Current Zoning: N1-A ANDO (Neighborhood 1, Airport Noise Disclosure Overlay)
Proposed Zoning: I-1(CD) ANDO (Light Industrial, Conditional, Airport Noise Disclosure Overlay)

Approximately 10.34 acres located north of Shopton Road, east of Sandy Porter Road, and west of Pinecrest Drive.

The petition proposes to allow 120,200 square feet of gross floor area of warehousing, warehouse distribution, manufacturing, office and other industrial uses permitted in the I-1 zoning district on two properties partially developed with single family detached dwellings.

Staff recommends approval of this petition upon resolution of outstanding issues related to transportation.

**RZ-1**  
Sheet 1 of 2

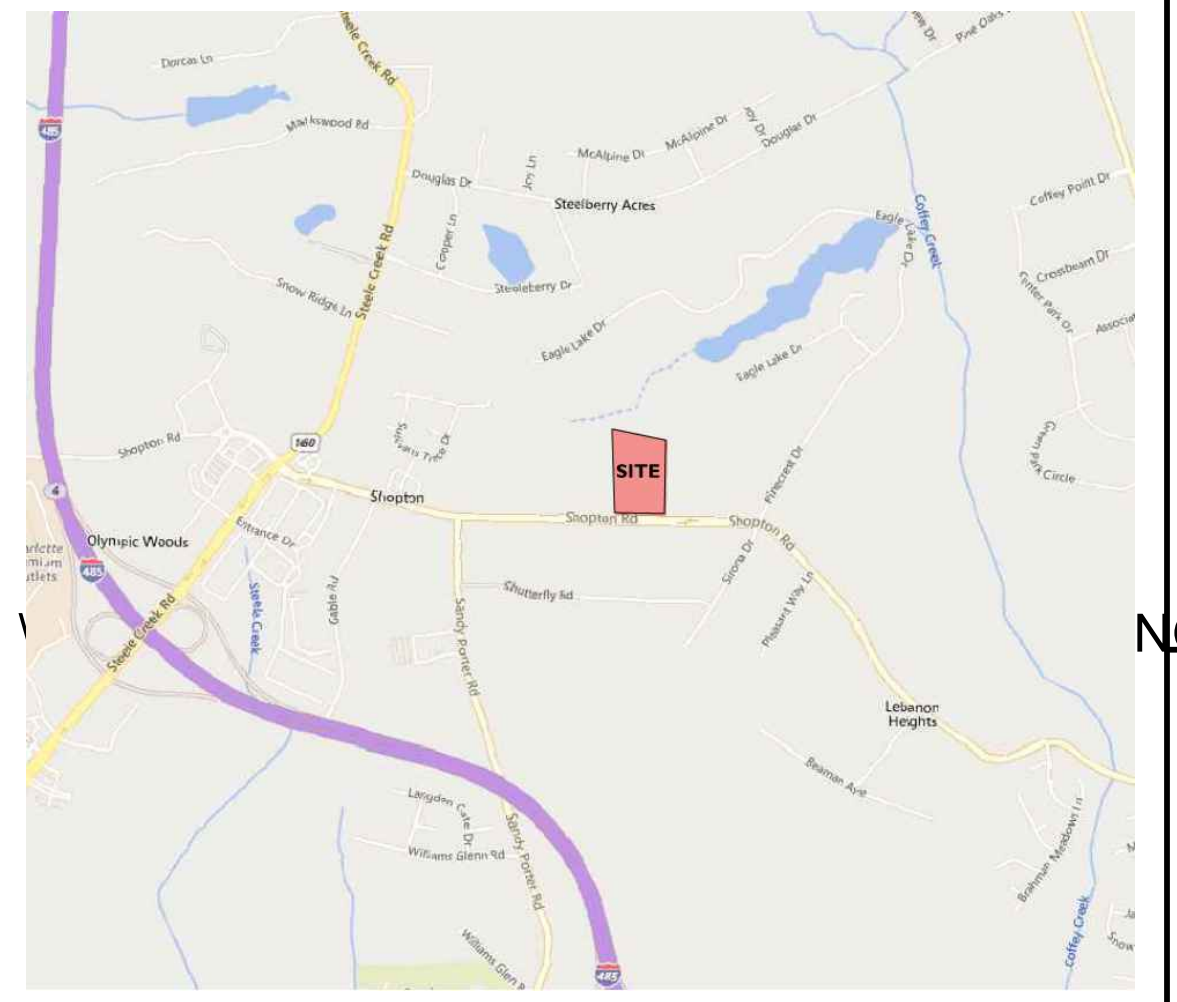
1. ~~Label and dimension the right-of-way from the road centerline.~~ **ADDRESSED**
2. ~~Revise site plan and conditional note(s) to commit to construct an 8-foot planting strip, and 8-foot sidewalk on Shopton Road per Chapter 19. The site plan shall label and dimension both items from the back of curb and gutter or edge of pavement.~~ **ADDRESSED**
3. ~~Revise site plan and conditional note(s) to commit to construct bicycle facilities by locating the curb and gutter 27' from the center line to meet the Council-adopted Charlotte BIKES Policy. Revise the bike lane to 5' wide with a 3' buffer.~~ **ADDRESSED**
4. Per coordination with NCDOT, revise site plan and conditional note(s) to commit to installing a left turn lane into the site from Shopton Road. **Show left turn lane or two-way left turn lane on site plan.**
OUTSTANDING

-
5. ~~Per coordination with NCDOT, revise the site plan to remove the sites eastern access. Line access up with the driveway across the street.~~ ADDRESSED
 6. Revise site plan to remove truck apron and widen driveway to accommodate appropriate turning movements. Add conditional note for driveway design to be finalized during permitting as approved by CDOT/NCDOT. OUTSTANDING
